BARNSLEY METROPOLITAN BOROUGH COUNCIL

264 DODWORTH ROAD, BARNSLEY, SOUTH YORKSHIRE, S70 6PN

**APPEAL STATEMENT SUBMITTED
ON BEHALF OF THE LOCAL PLANNING AUTHORITY**

**LPA REF: 2024/1023
PLANNING INSPECTORATE REF: APP/R4408/W/25/3370772**

Proposed Site Plan

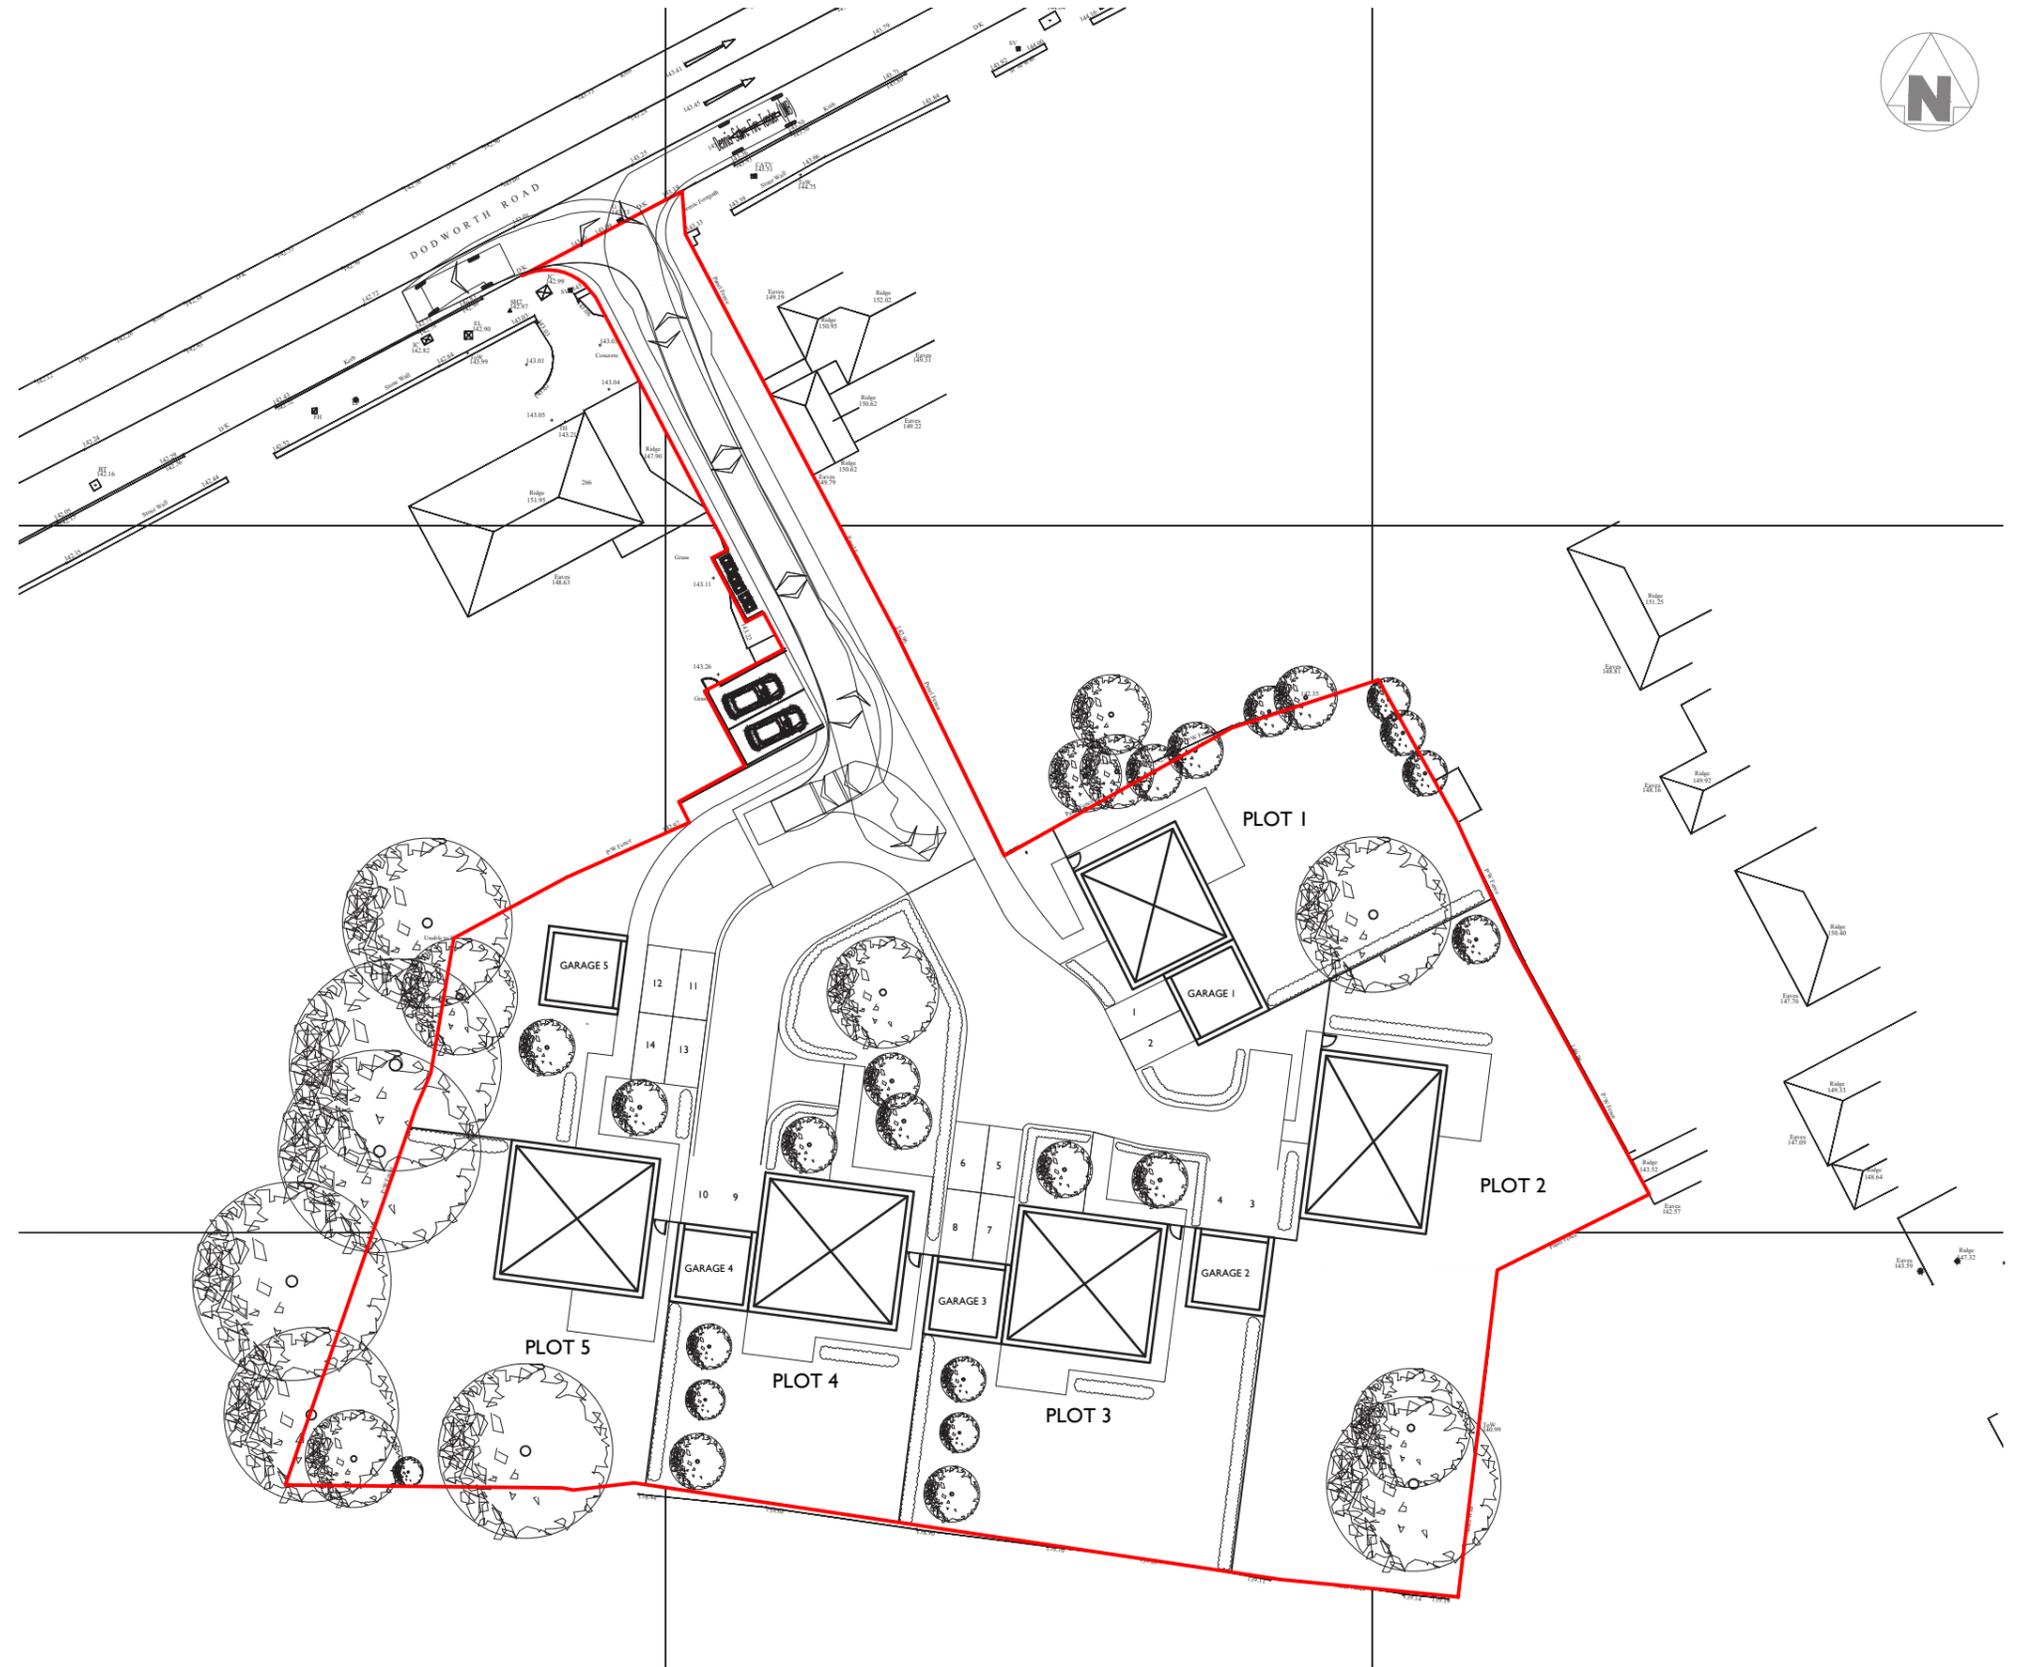
Notwithstanding the above, the site plan shows swept paths for a refuse vehicle, however it should be noted that refuse vehicles do not enter shared private drives and as such the proposed refuse collection area is unsuitable as it is not adjacent to the public highway. That being said, I would have further concerns over refuse collection for an additional 5 properties being carried out on the public highway due to the additional time that will be required for a refuse vehicle to remain stationary whilst undertaking the collection on this busy arterial route. I would also point out that the swept paths show the vehicle crossing into the opposing lane when taking a left out of the site. Whilst I am mindful that I have advised that the vehicle shown would not enter the site, it is likely that larger delivery vehicles would, and as such, there is the potential that these vehicles will also cross into the opposing lane. Due to the number of vehicles that travel along Dodworth Road, it is imperative that vehicles do not cross into the opposing lane”.

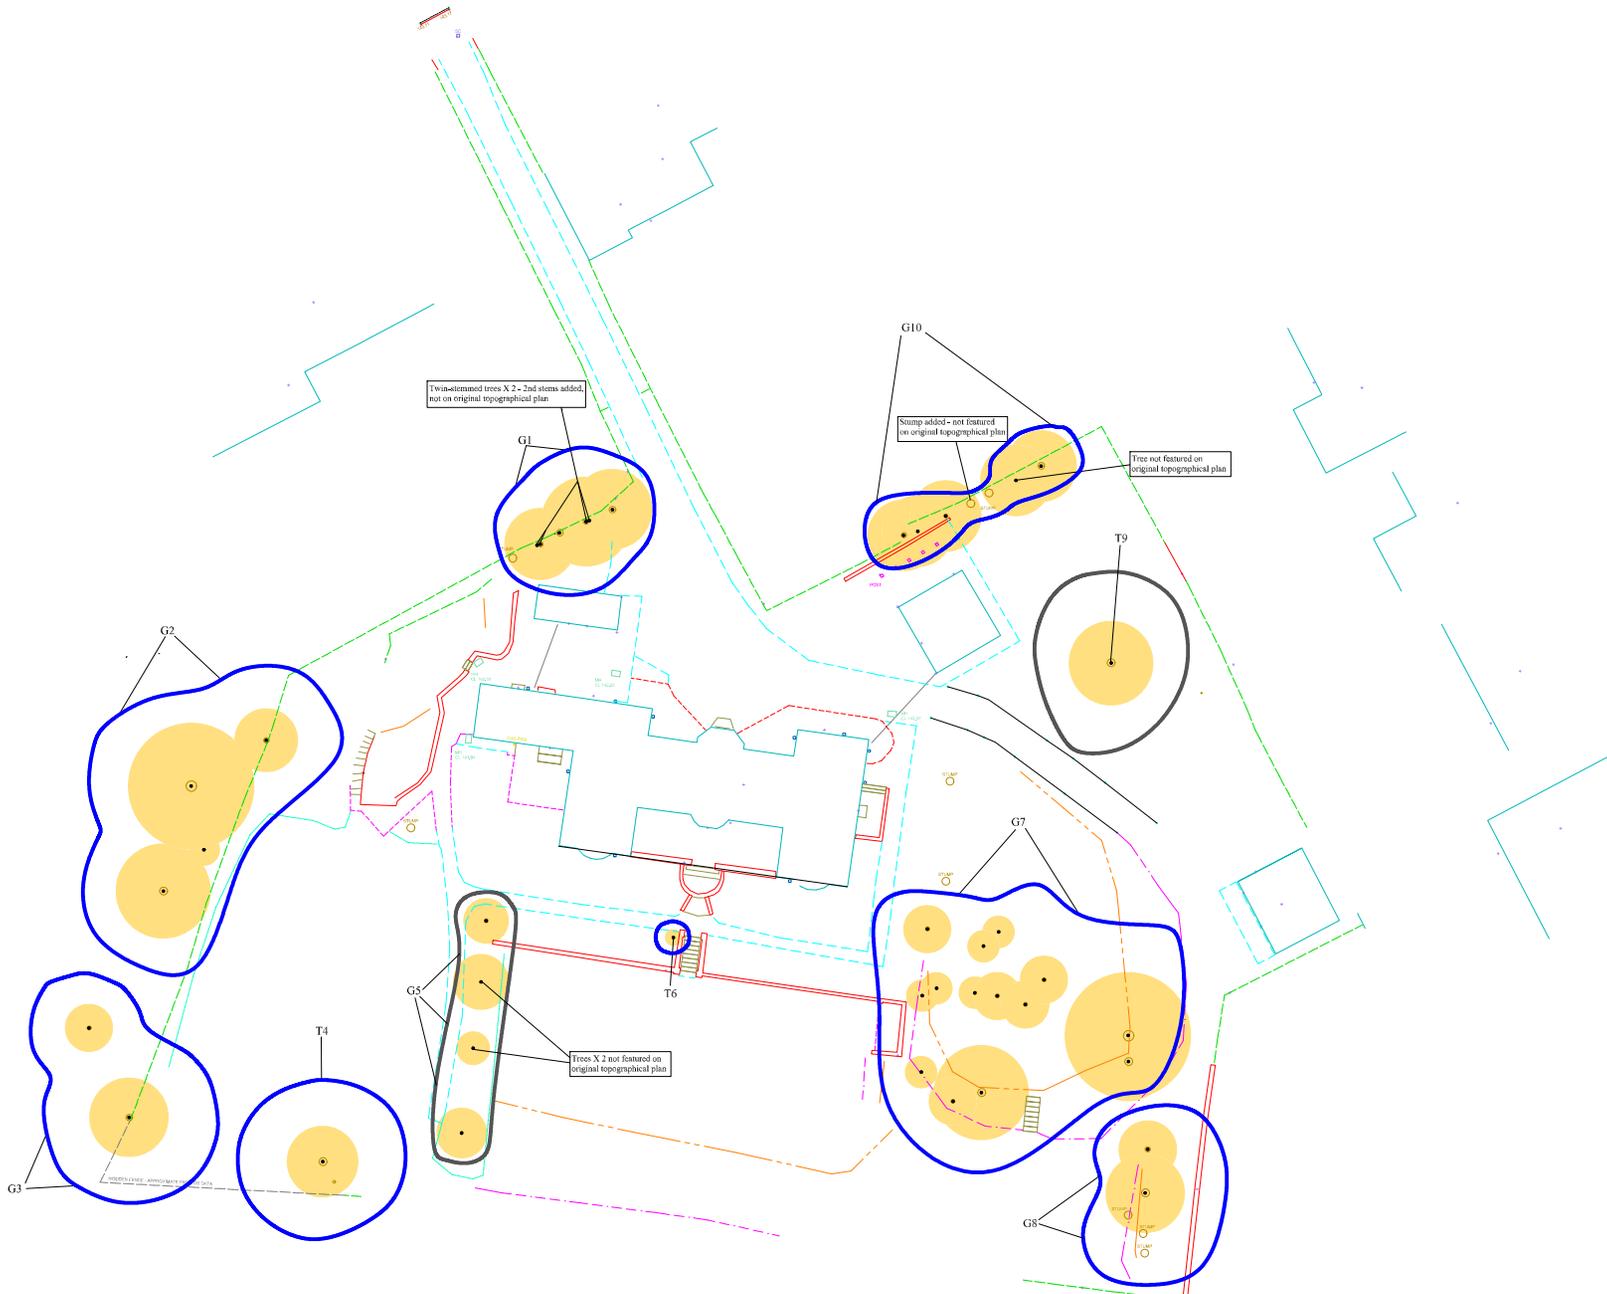
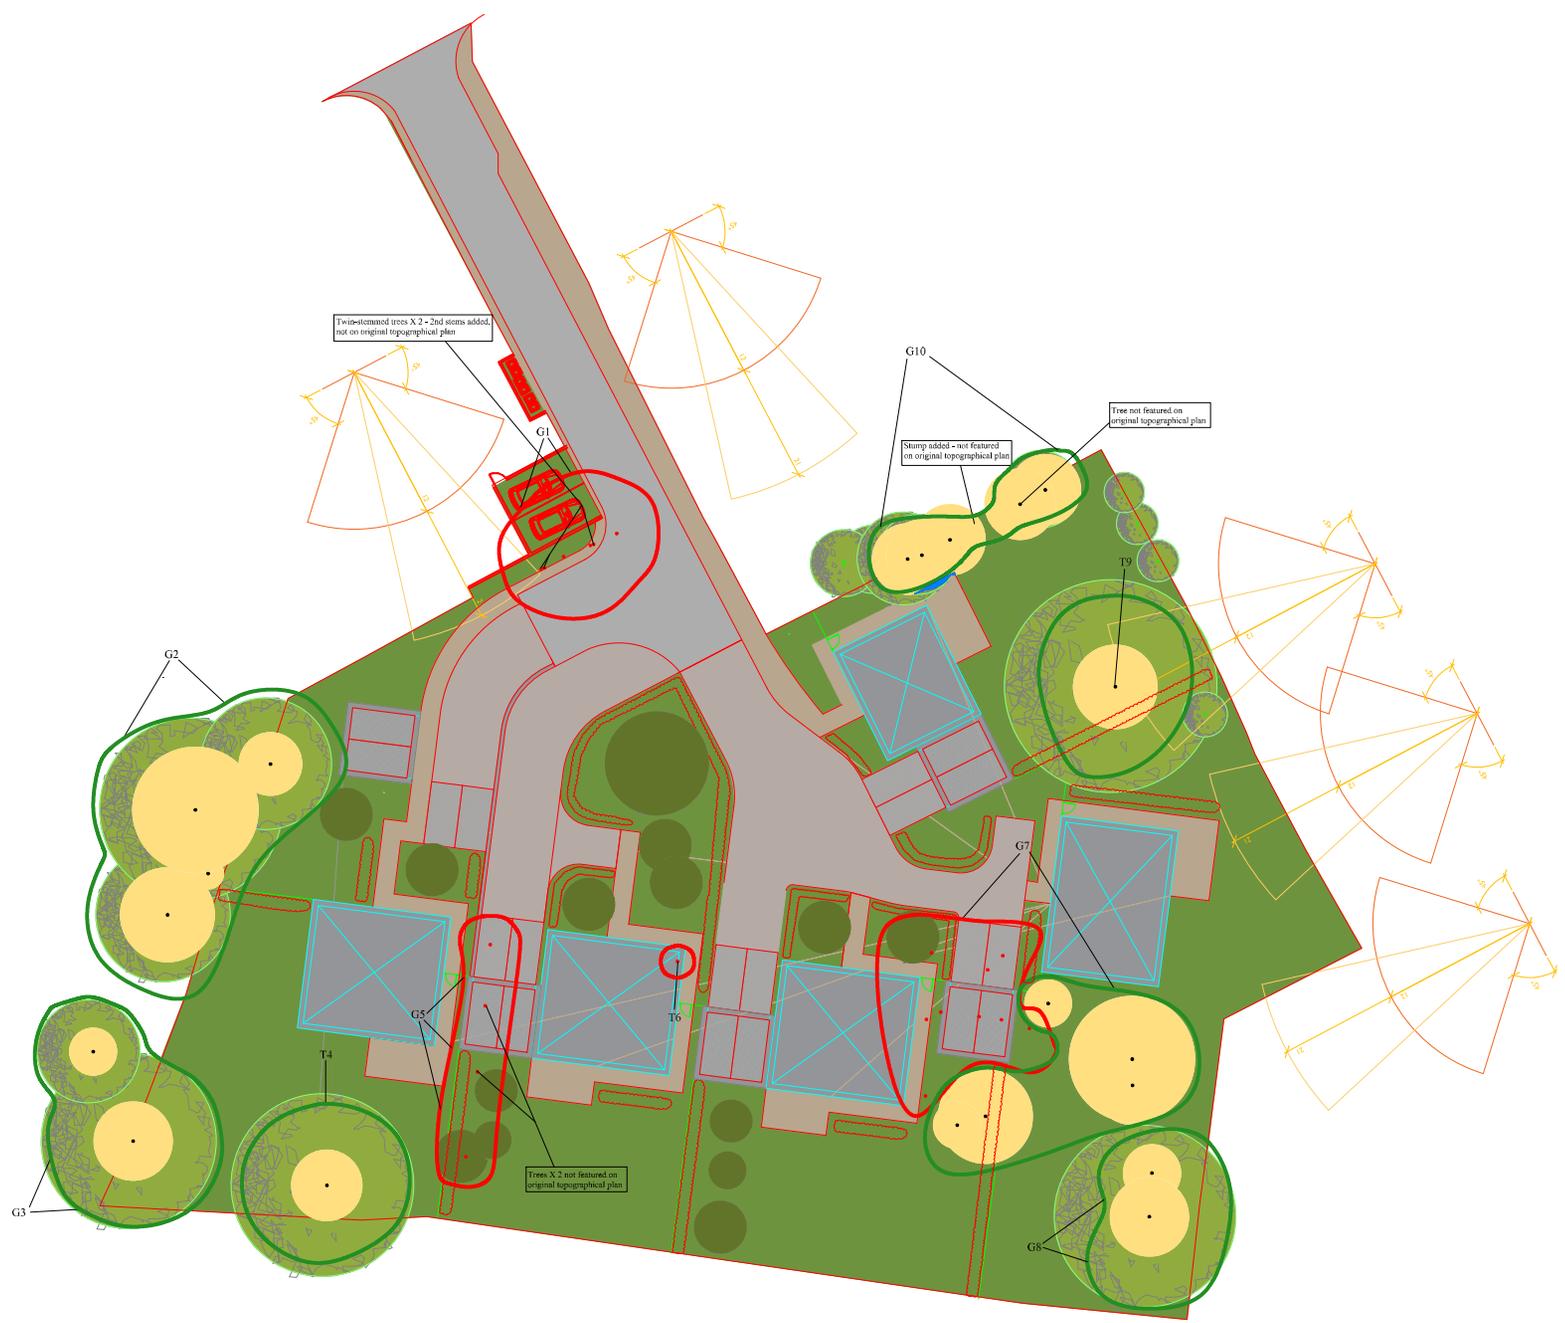
Forestry Officer – The scheme put forward does not seem to pay particular regards to the trees present on site as demonstrated by the impacts on category B trees and groups.
